Subject: FW: BN/35/19/DOC Lake Lane

From: Joanne Lewis <Joanne.Lewis@arun.gov.uk>
Sent: 05 June 2019 10:55
To: Simon Davis <Simon.Davis@arun.gov.uk>; Planning.Responses <Planning.Responses@arun.gov.uk>
Subject: RE: BN/35/19/DOC Lake Lane

Thank you for the additional information submitted, however before I can recommend discharge of the condition I would request that the developer confirm that their proposed scheme conforms with the design guidance in the Institution of Lighting Professionals, Guidance Notes for the Reduction of Obtrusive Light for Zone E2 – Rural.

Pharola DS

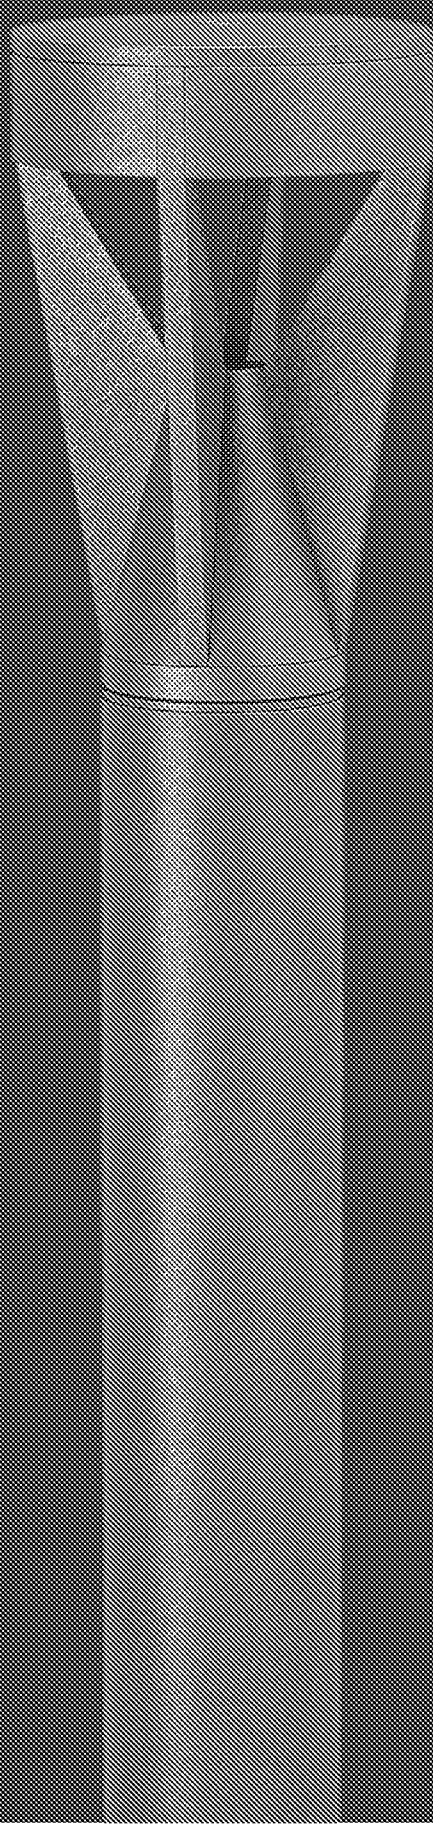
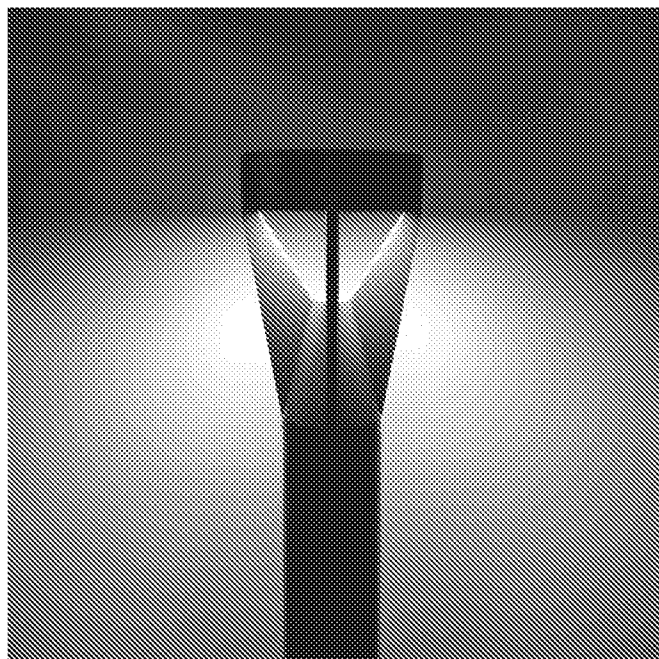
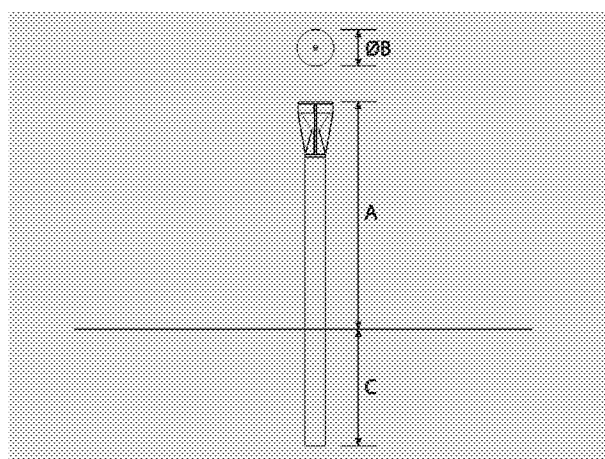
Please see attached response from Environmental Health. Can you provide on illumination levels and light spillage from the proposed lighting and justification as to why downward

facing light sources are not being used.

I have consulted with my client and in response to the Environmental Health officer's consultation we wish to amend the external lighting proposal by selecting a 'dark skies' compliant light fitting.

The 'Pharola' bollard selected does not emit 'upward' light but does illuminate sideways, in keeping with its purpose to illuminate specific areas of the private access road there by allowing safer passage for the residents during darkness.

Attached is Dwg1748-52A together with the 'lighting bollard specification' which we request be substituted under the above application please.
